Rezoning Transportation Analysis

Petition Number: 2021-182

Date	Description
08-20-2021	First Review (KP)

REZONING SITE PLAN

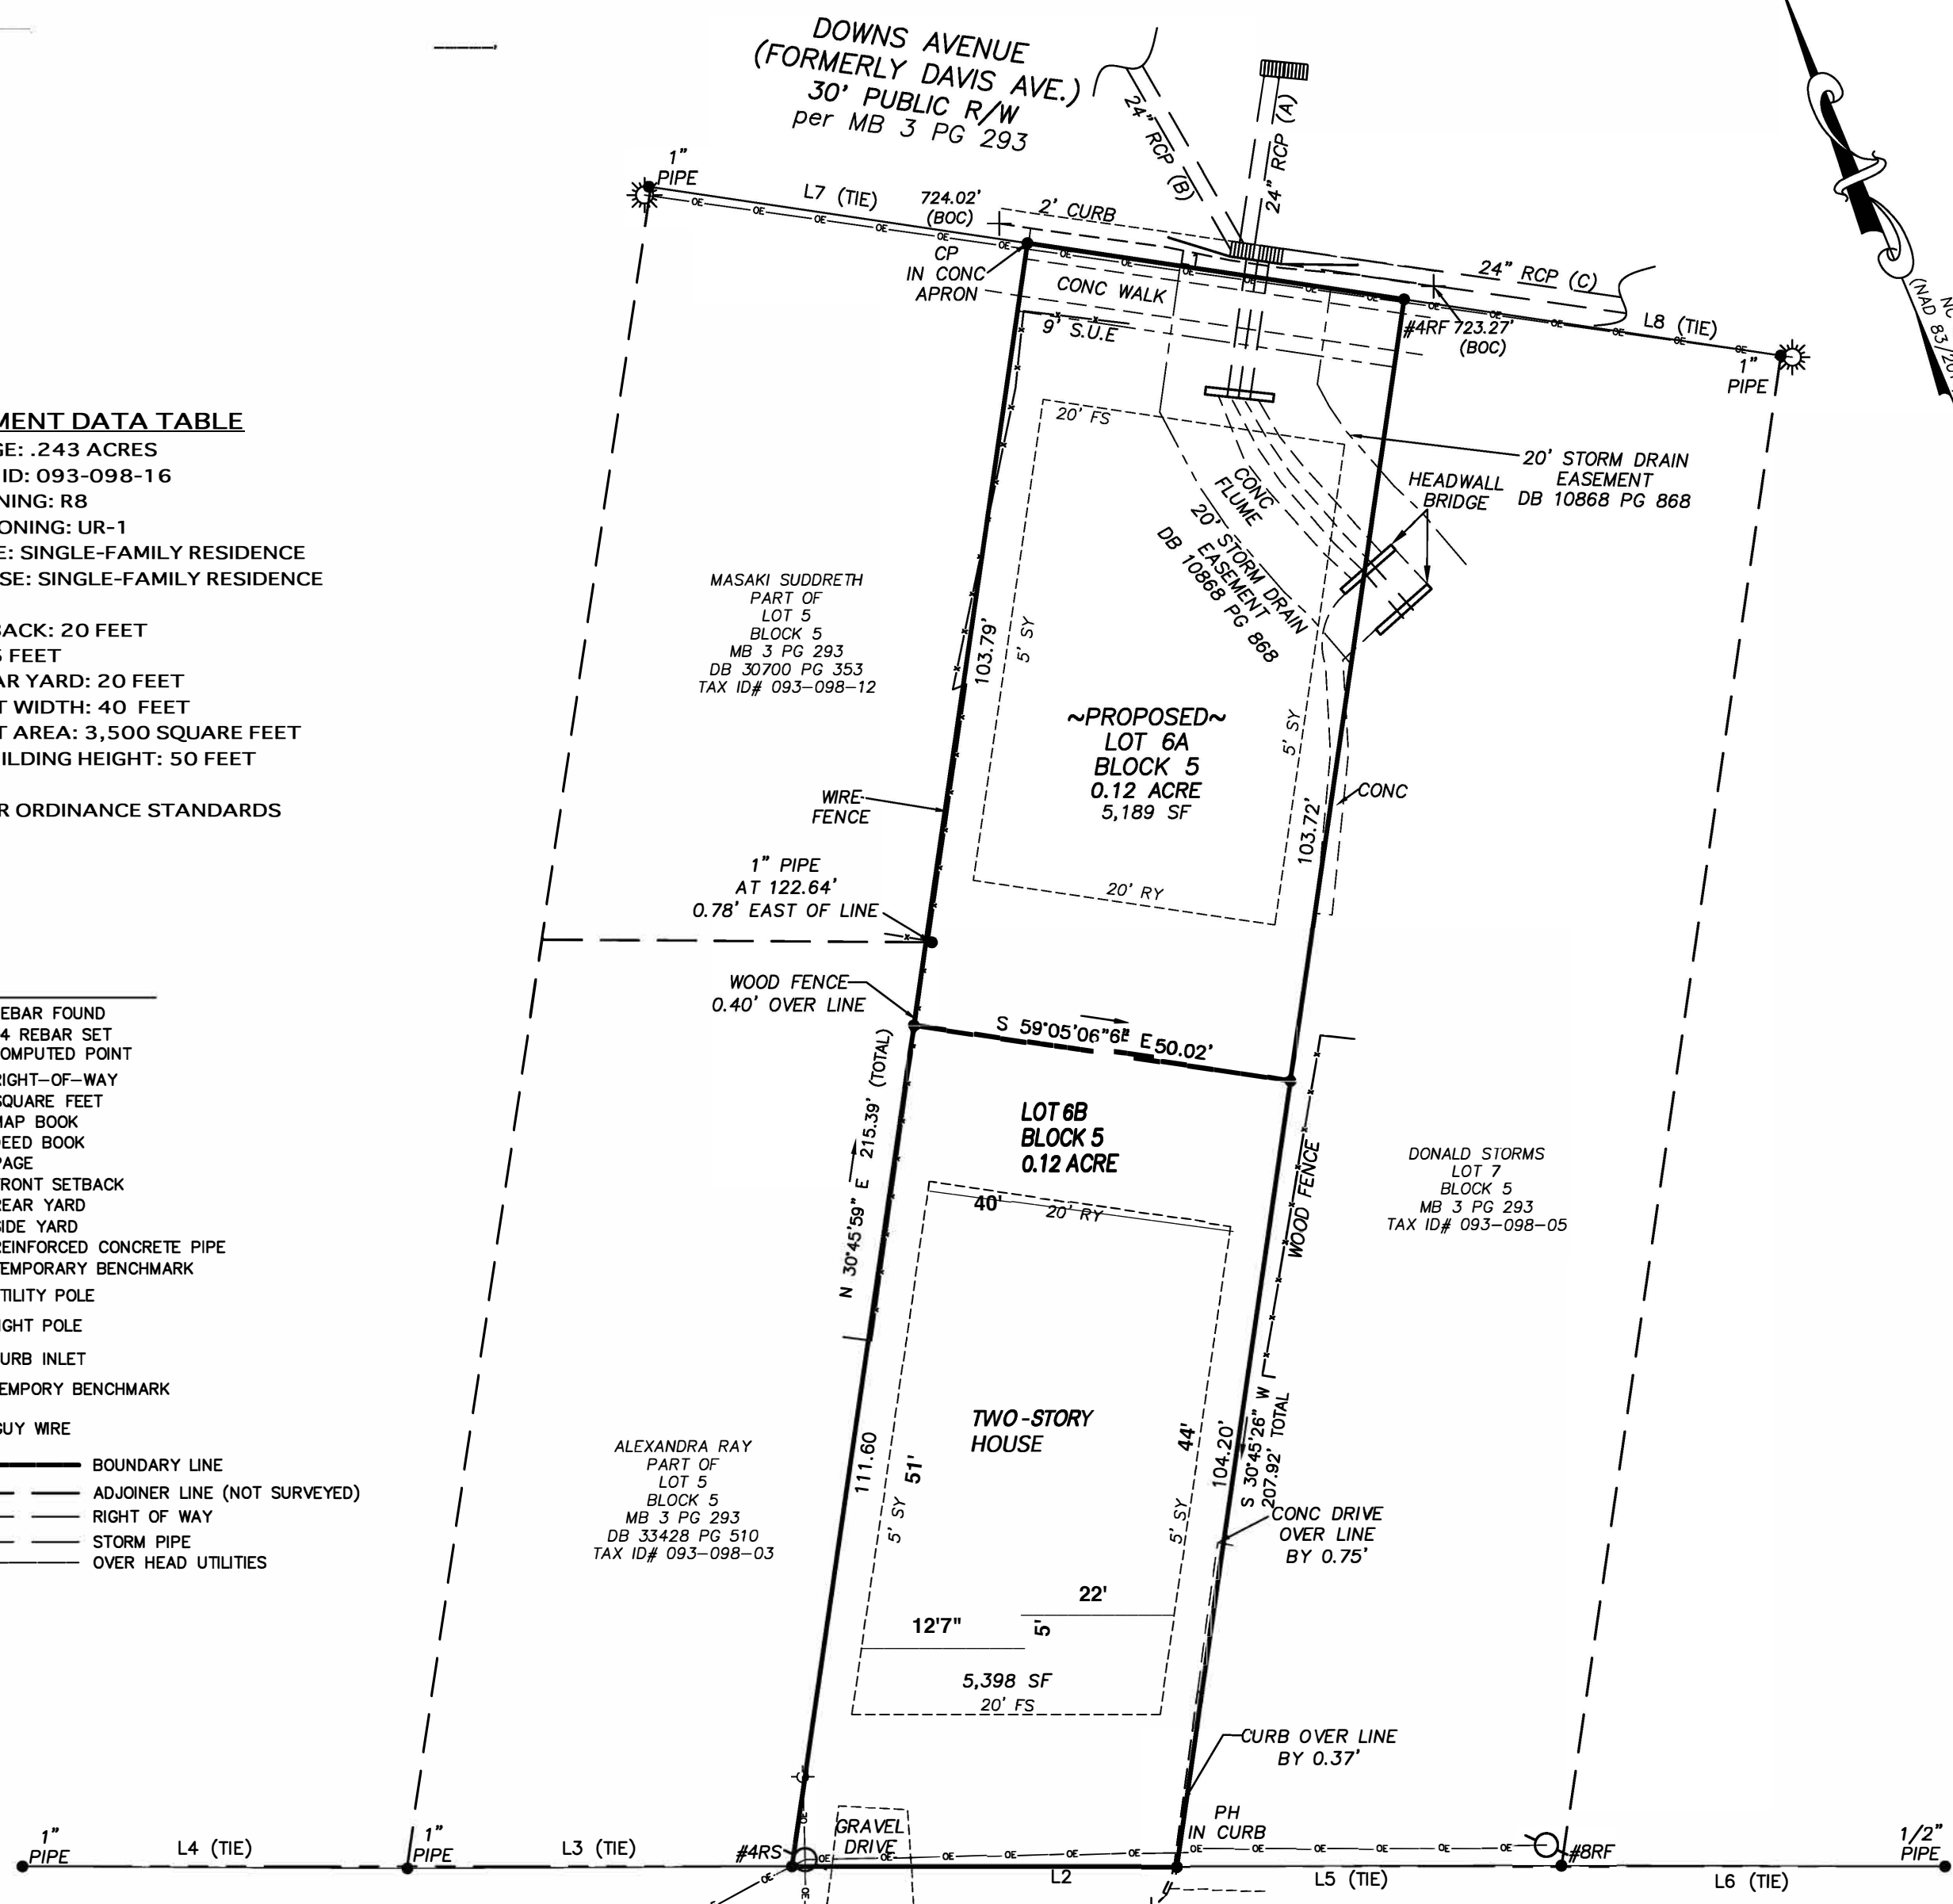
- Curb line:** The proposed zoning district has a setback measured from back of the existing or proposed future curb line.
 - Downs Avenue:** The future location of the back of curb will be 13-feet from the existing centerline.
 - Shamrock Avenue:** The future location of the back of curb will be 27-feet from the existing centerline.

Label and dimension the existing and future back of curb from the existing centerline of each road on the site plan.

- Downs Avenue:** Revise site plan and conditional note(s) to commit to dedicate 28-feet of right-of-way from the road centerline.
- Shamrock Avenue:** Revise site plan and conditional note(s) to commit to dedicate 45-feet of right-of-way from the road centerline.

The site plan shall label and dimension the right-of-way from the existing centerline of each road.

- A site plan note(s) specifying dedication and fee simple conveyance of all rights-of-way to the City and/or NCDOT before the site's first building certificate of occupancy is issued is needed. CDOT requests rights-of-way set at 2' behind back of sidewalk where feasible.

- Revise the conditional notes by including the following note:
